April 14, 2016

**Subject: 1039 Riverside Street, Second Tee Business Park Unit 2
Site Plan Revisions per Internal Review and City Comments
Letter of Response #1**

SHEET NUMBER
 A-2
 SHEET 2 OF 2

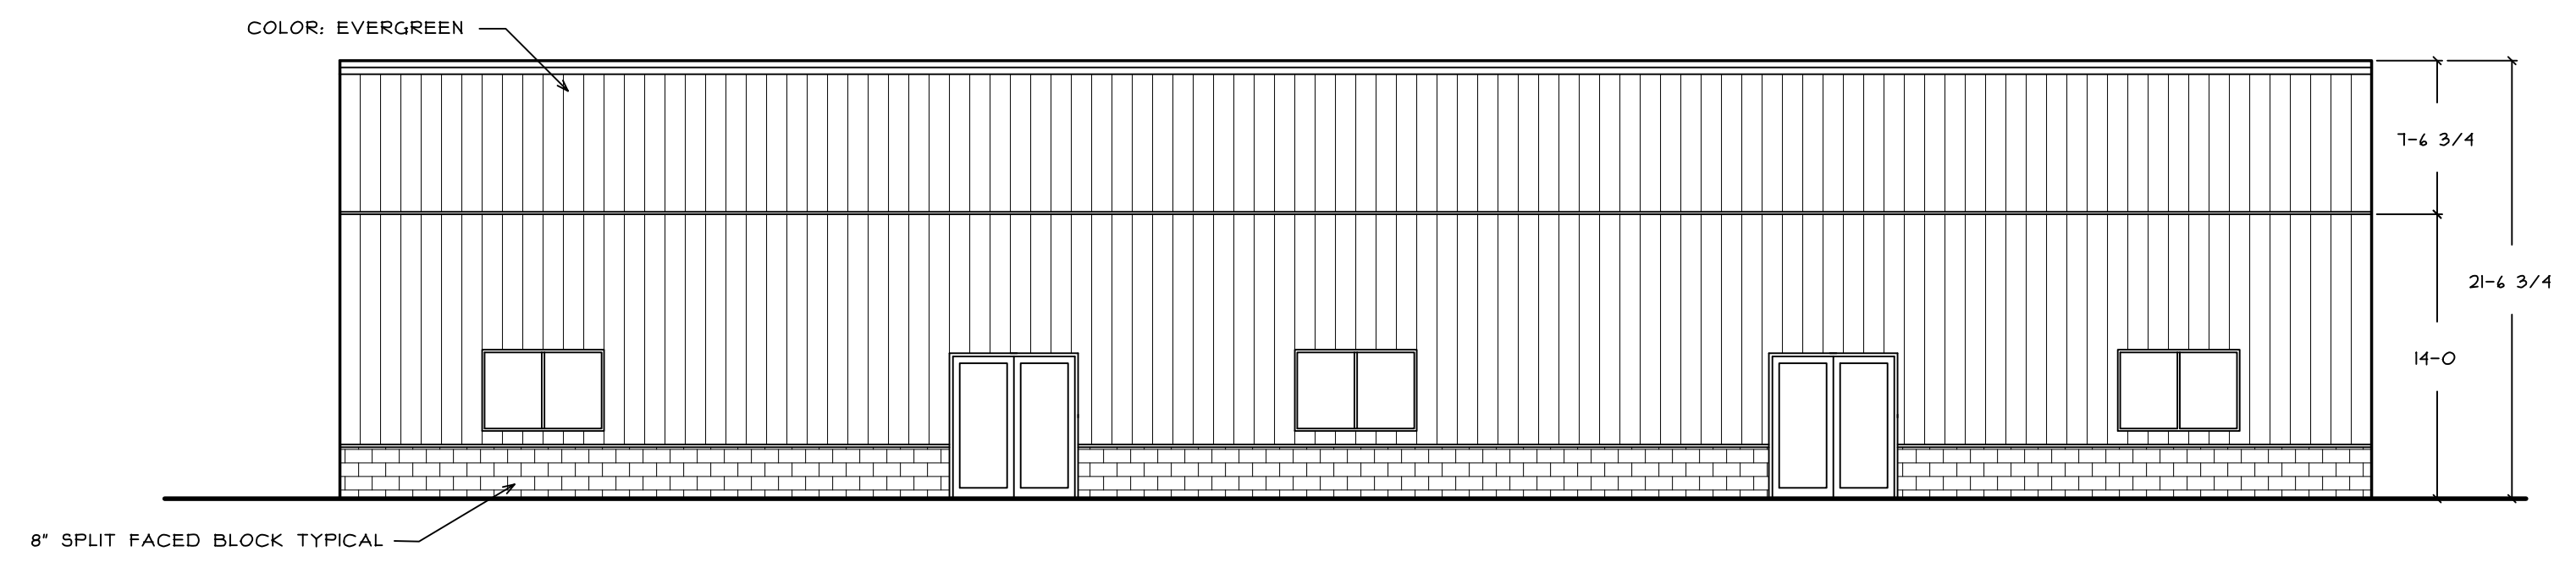
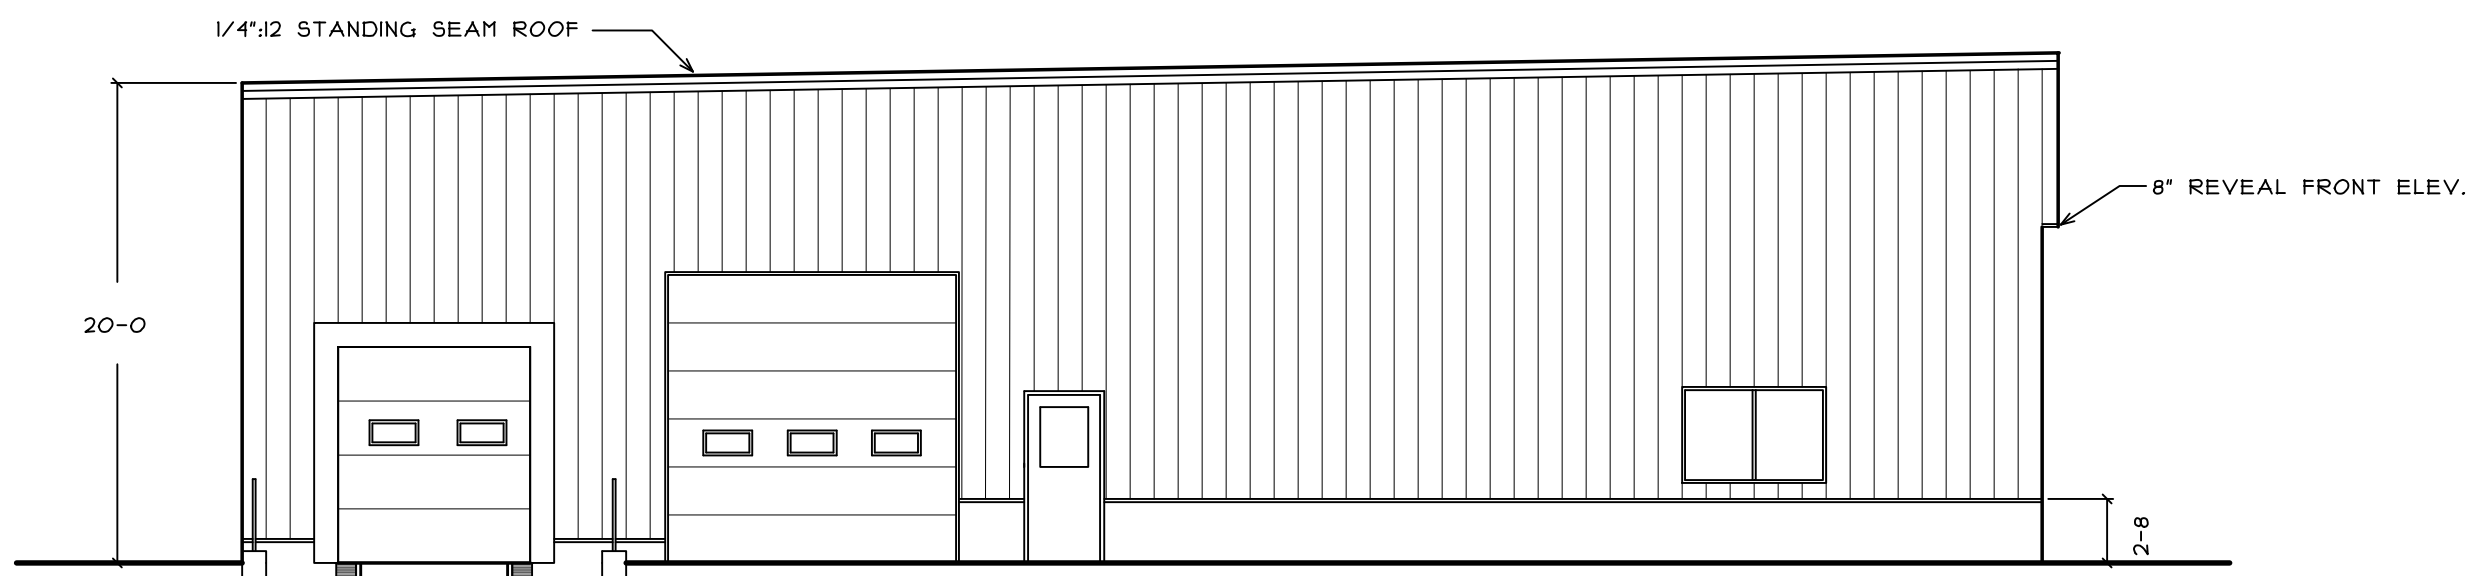
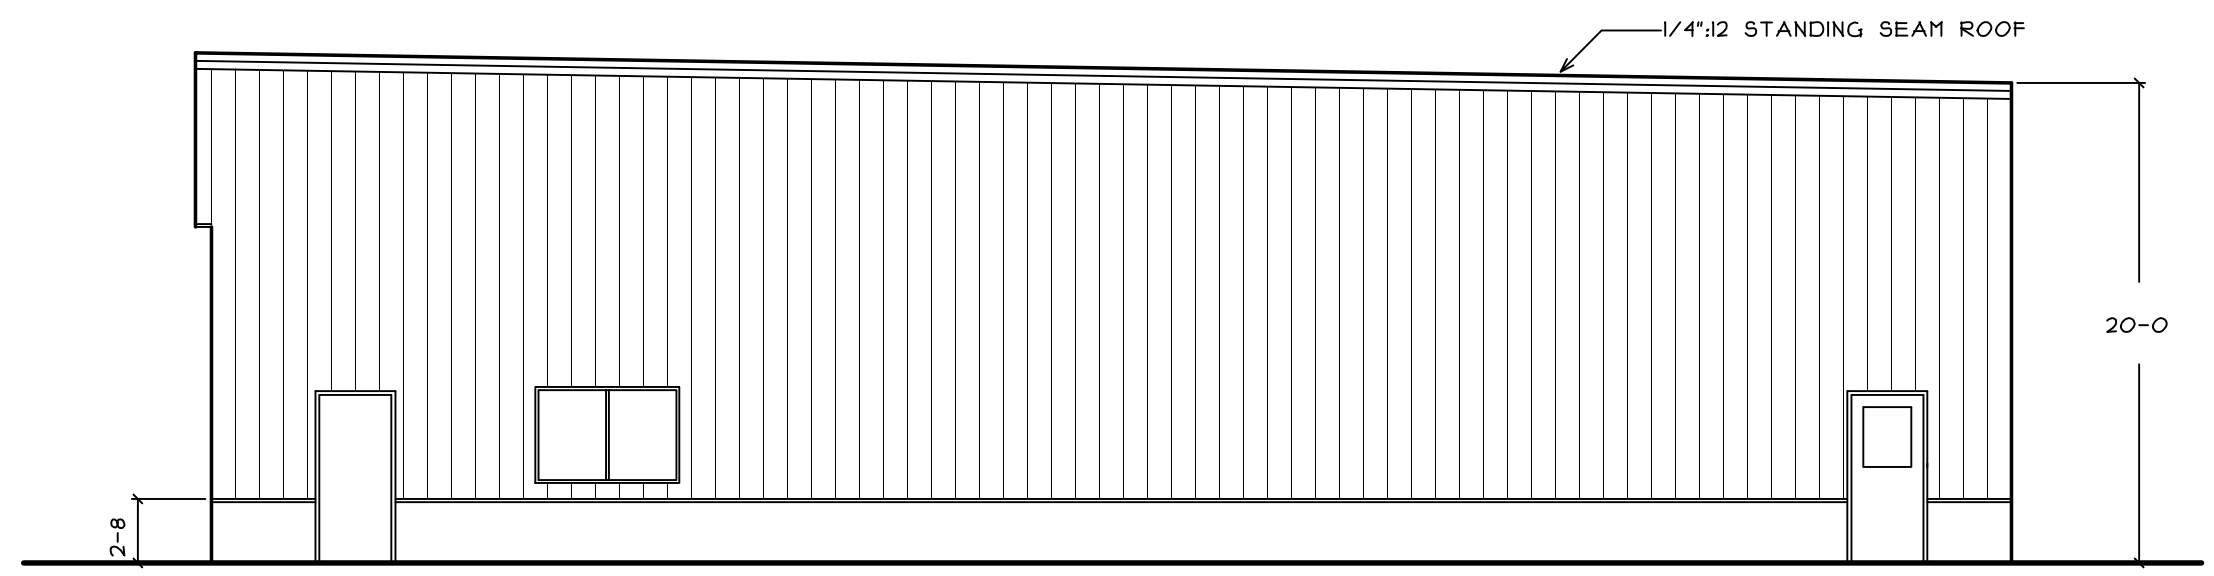
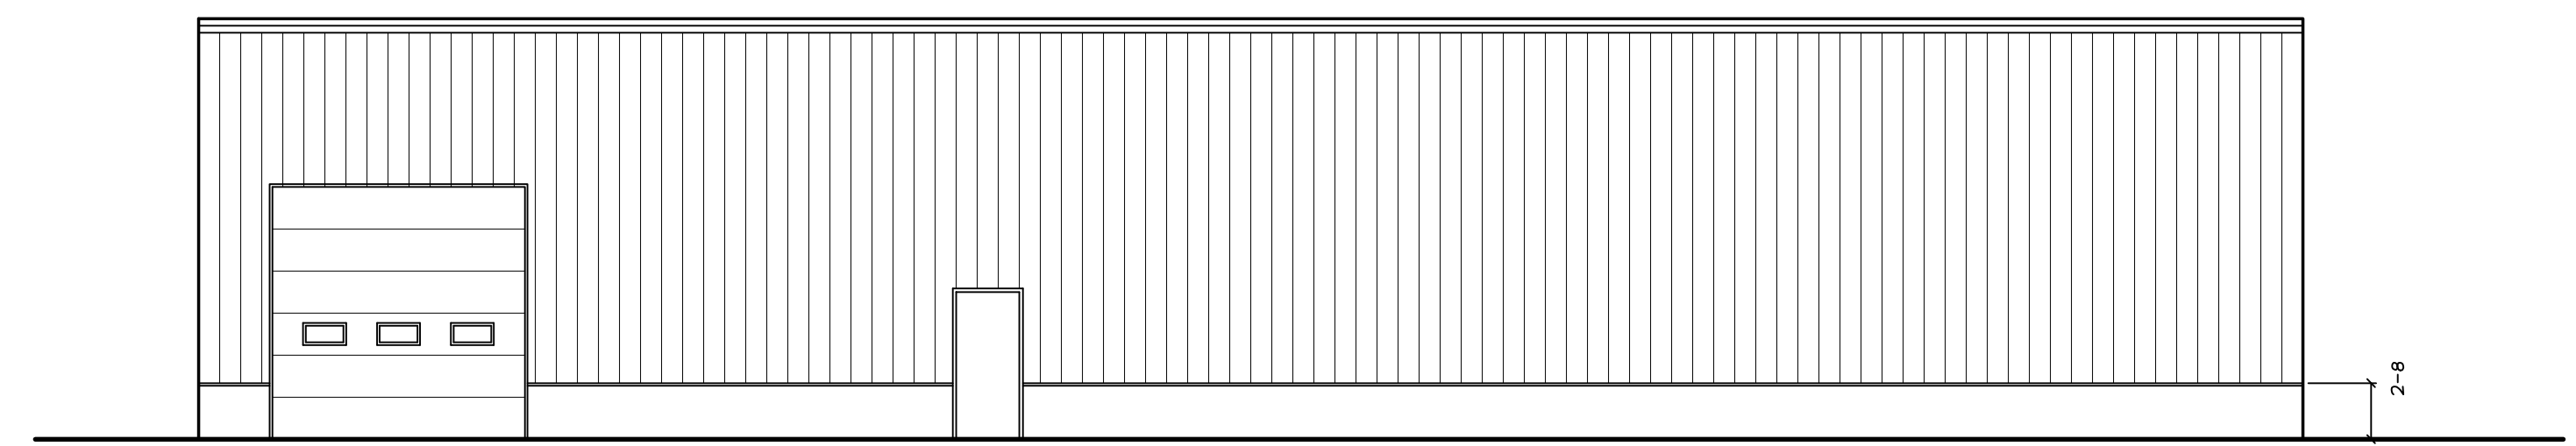
3. Snow storage zones at the edges of the parking area have been identified on the plan.
4. The building layout has been modified to include a traditional loading dock on the left rear corner of the unit (NE corner). This dock area will be accessed from Tee Drive. An entry door is also located on the north side of the building.

5. An at-grade overhead door will be provided on the right rear corner of the building (SE corner) with a pavement connection to Tee Drive.
6. The drainage layout has been slightly modified based on the loading area revisions.

**(A) BIKE HITCH MOUNTING DETAIL**  
N.T.S.

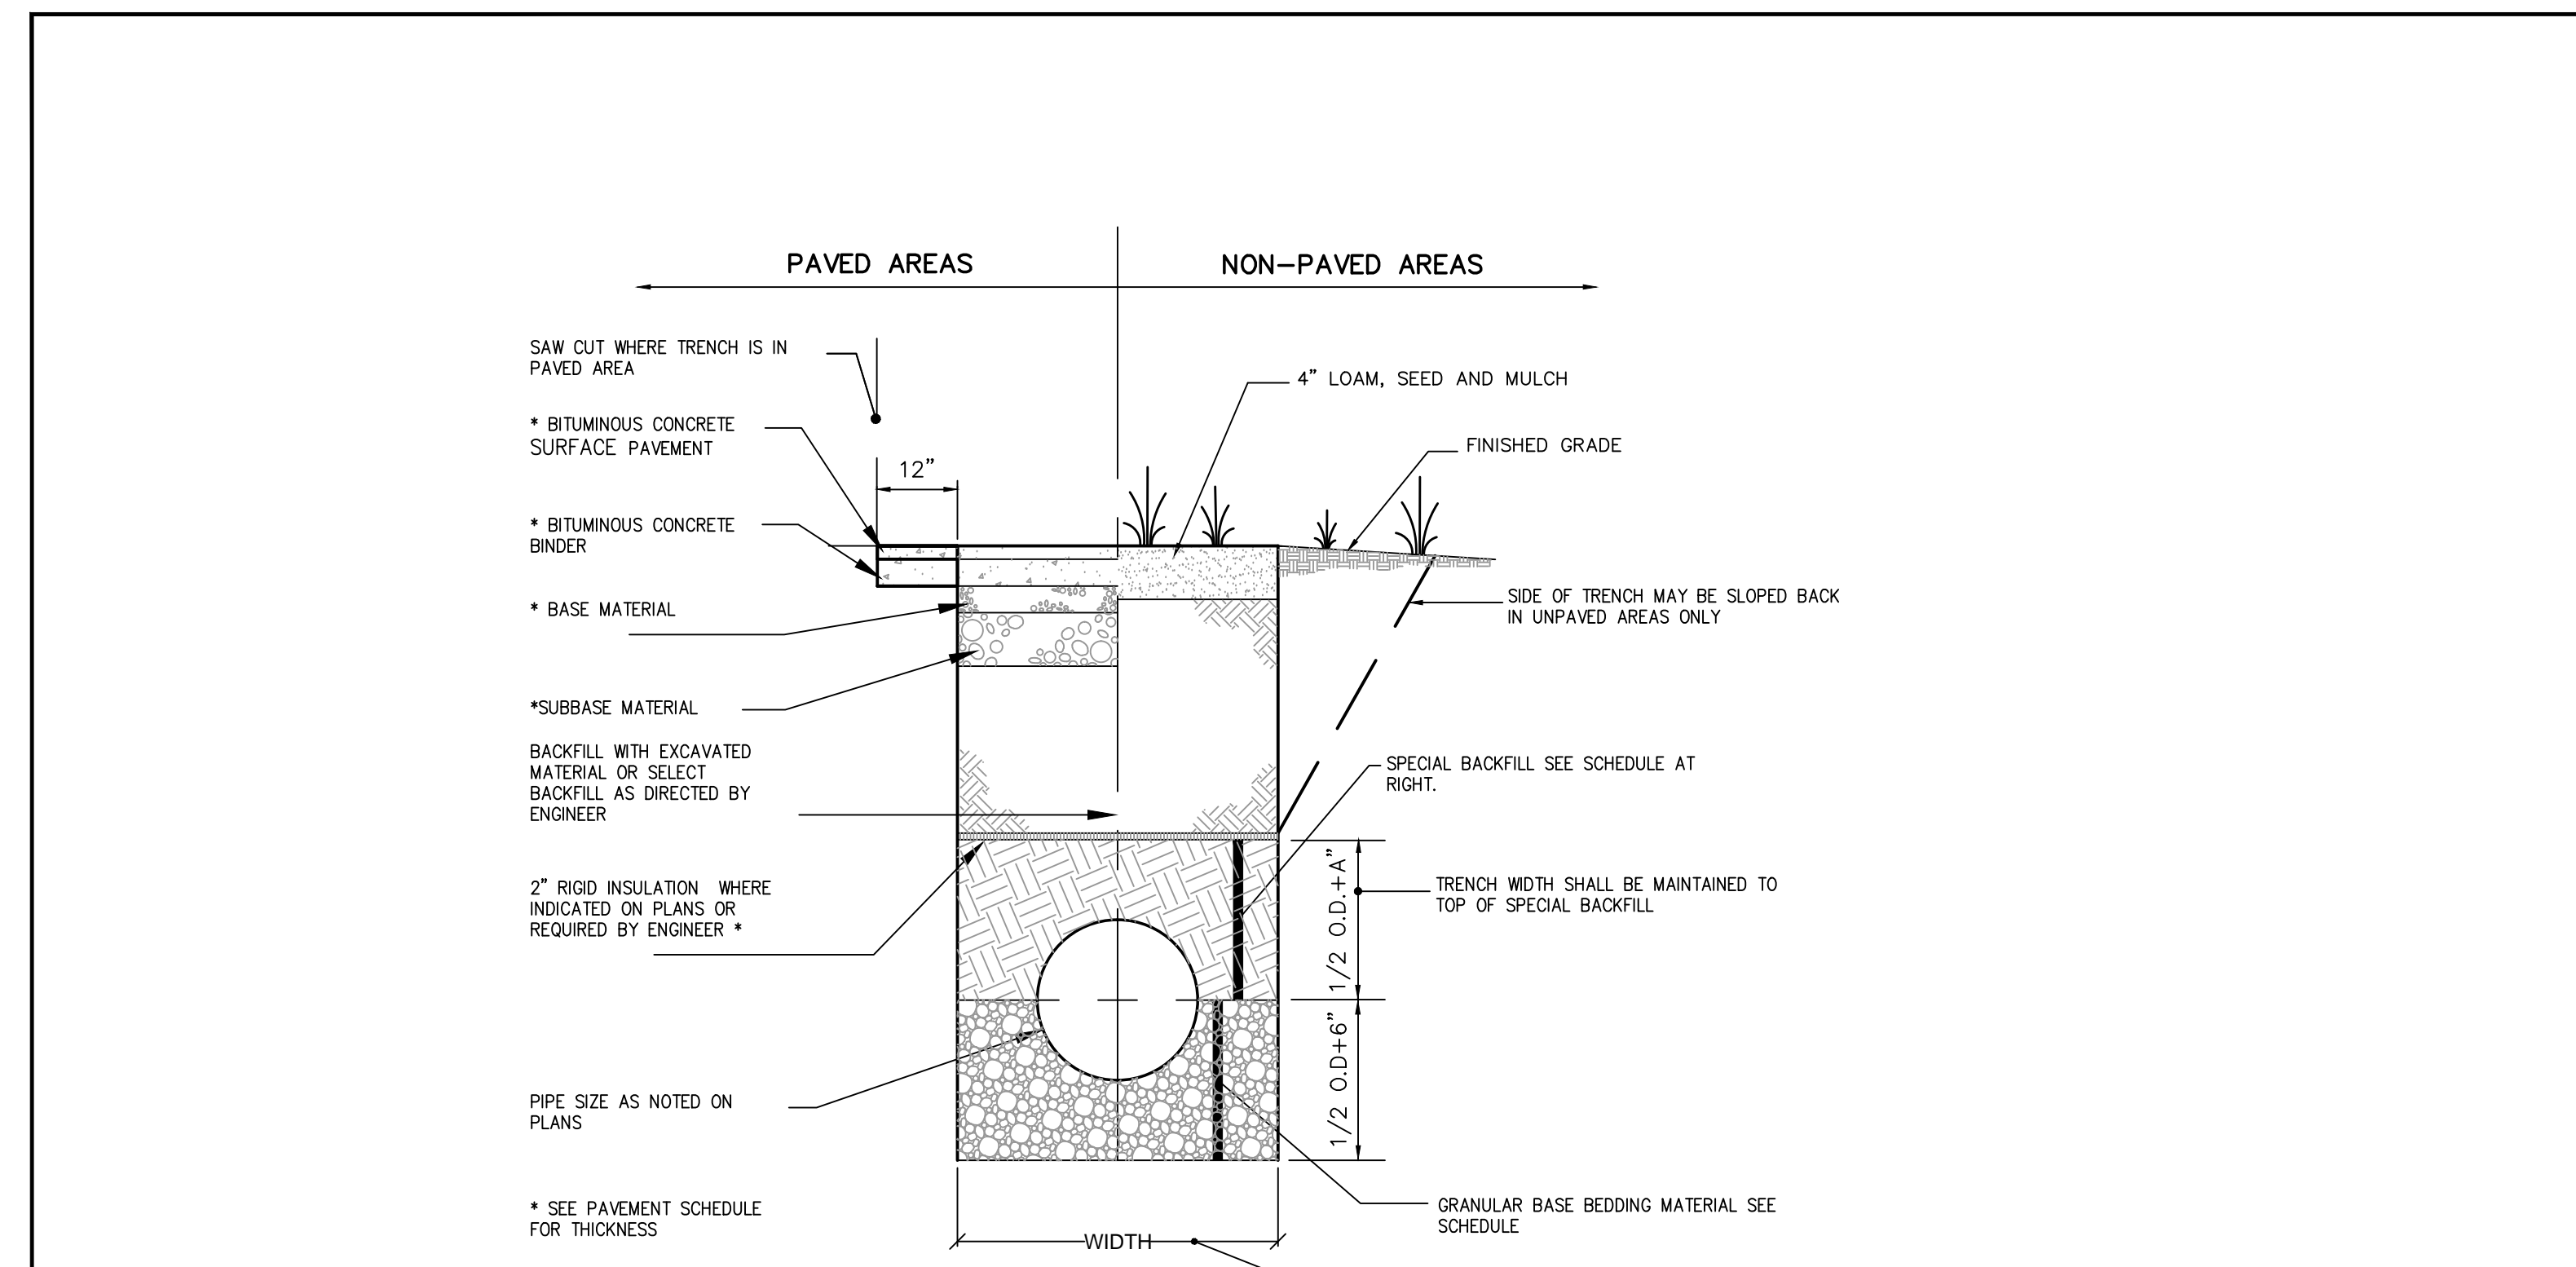
1. Two (2) Dero bicycle hitch posts will be provided at the front of the building within an expanded front sidewalk area.
2. A 5' side bituminous sidewalk will be extended from the existing sidewalk along Riverside Street to the front of the Unit 2 site.
